**REQUEST**

Current Zoning: N1-B (neighborhood 1-B), N2-B (neighborhood 2-B)  
Proposed Zoning: N1-B(CD) (neighborhood 1-B, conditional), N2-B(CD) (neighborhood 2-B, conditional), and CG(CD) (general commercial, conditional)

Approximately 80 acres located on the east side of East Independence Boulevard, north of Hayden Way, and west of Sam Newell Road.

The petition proposes to allow all uses permitted by right and under prescribed conditions in the N1-B, N2-B, and CG zoning districts, and to provide for commitments related to Irvins Creek Greenway and the East/West Connector on acreage largely vacant save for a single-family home built in 1928.

**RZP-2023-069
 REZONING**

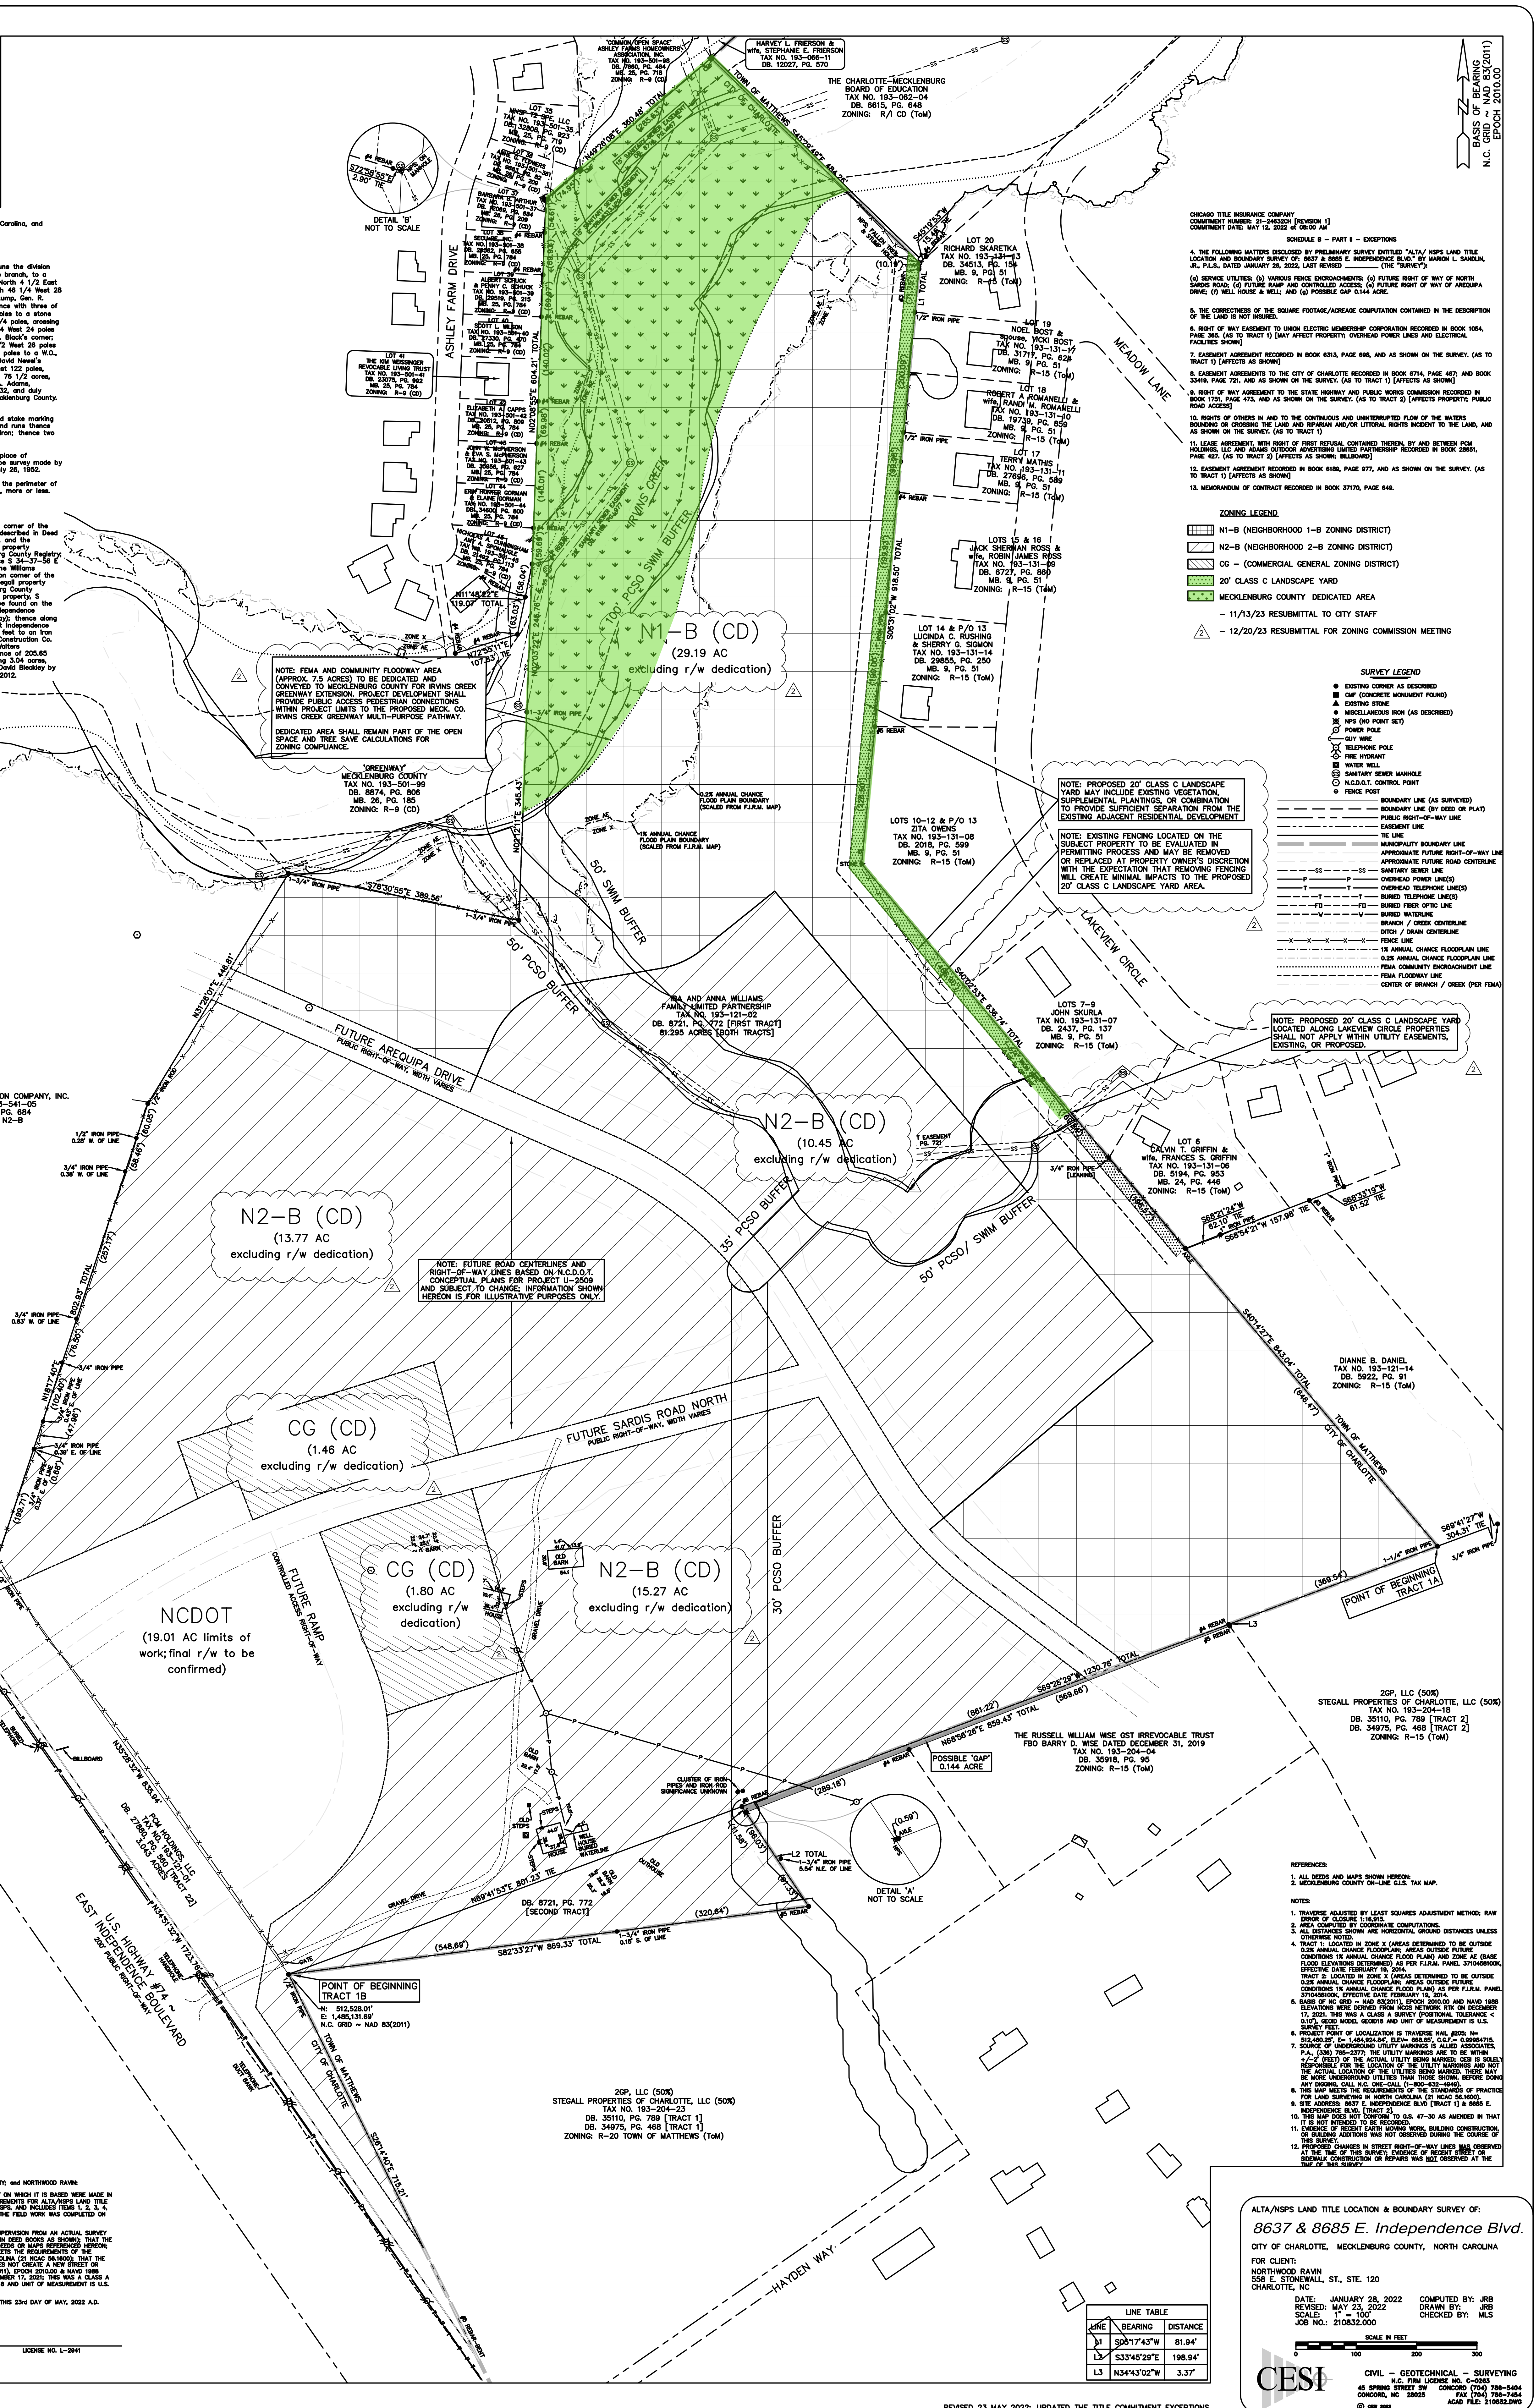
1. MCPR requests minimum of 3.5 acres to be dedicated and conveyed to Mecklenburg County for a future local park. This requested park land shall be adjacent to a public right-of-way for access and is conducive for the development of the typical amenities found in a local park and cannot include tree save parcels or stormwater BMP's. Ideally, the proposed park land shall be adjacent to the requested greenway access easement. **Addressed**
2. The dedication note should read: "...to be dedicated and conveyed to Mecklenburg County for Irvins Creek Greenway..." Easements are conveyed to Mecklenburg County, not to the Park and Recreation Department. The creek is Irvins Creek, not Irwin Creek. **Addressed**
3. The notes should be revised to reference "Irvins" Creek. **Addressed**

4. Label zoning of abutting properties. **Addressed**
5. A portion of the proposed vegetative setback crosses an existing sanitary sewer easement. **Addressed**
6. Please define what is meant by a vegetative setback and provide a planting schedule based on the landscape yards in the UDO. **Addressed**
7. The notes reference a 20-foot vegetative setback and a 20-foot Class C buffer. Please clarify which standard is being used and ensure labeling and notes reflect correct. Please note the Charlotte UDO references landscape yards as a standard. **Addressed**
8. Please remove references to buffers and use the UDO terminology of Landscape Yards. **Addressed**
9. There appears to be a fence along portions of the property line. Please confirm if this is existing to remain, be removed, or proposed. **Addressed**

10. Add a development condition to reserve right-of-way for all four legs of the Future Sardis Road North/Arequipa Drive extension. Currently, the plans reserve ROW for three of four legs. Right-of-way reservation areas for all future streets should be located according to the CDOT Streets Map and NCDOT TIP project plans. **Addressed**
